Historic England

Our ref: L01344410

13 January 2021

**THE GUILDHALL, BRIDGE STREET, LYME REGIS, DT7 3QA
Application No. WD/D/20/002799 & WD/D/20/002800**

| 19/045/SK1 | |

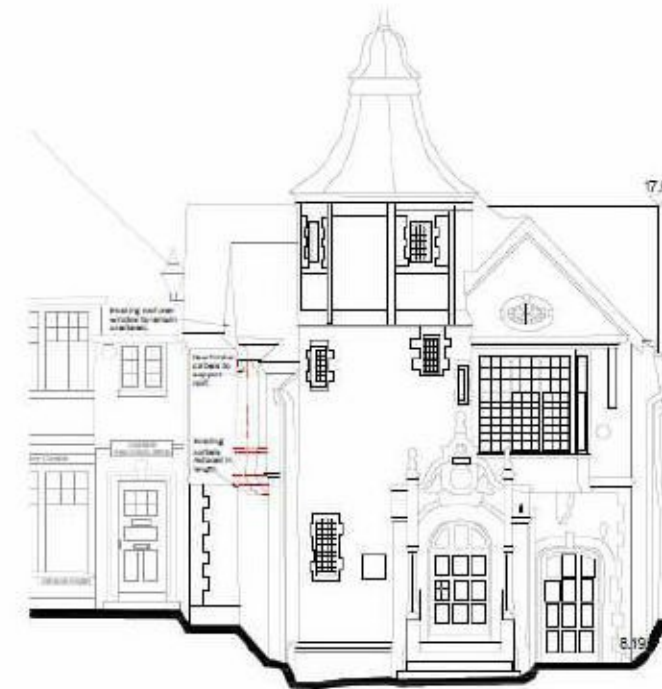
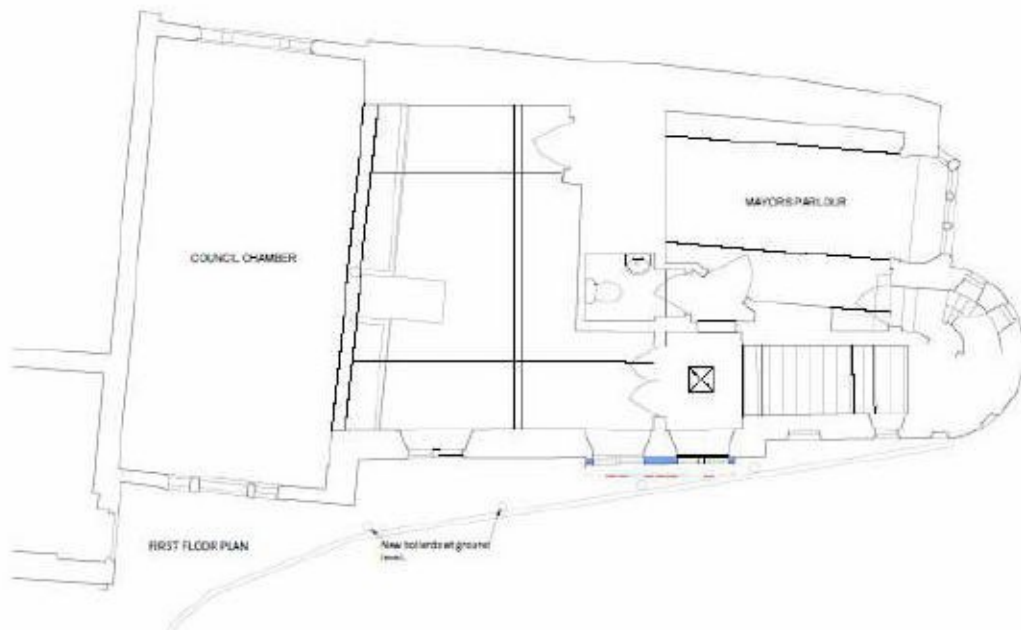
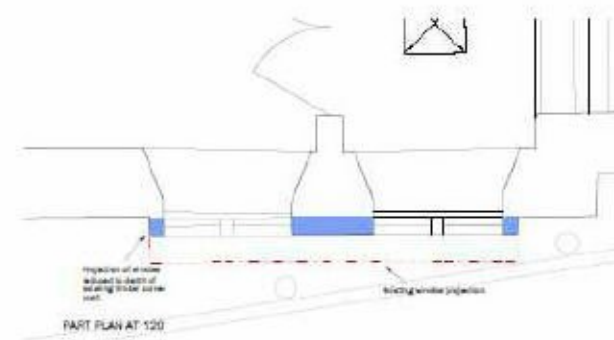
These three options were discussed on site and it was agreed that option A required the least physical intervention into the fabric, would preserve much more of the form and character of the façade but would also maintain the existing window layout within the first floor Council chamber. The existing corbels which support the oriel could be shortened to support a flattened projection and new corbels added to support the roof structure which remains unaltered.

Given the current and on-going risk to the building, the comprehensive, albeit fruitless investigations into alternative, non-invasive options and the sensitivity of the design proposed, Historic England has no objection to these works on heritage grounds.
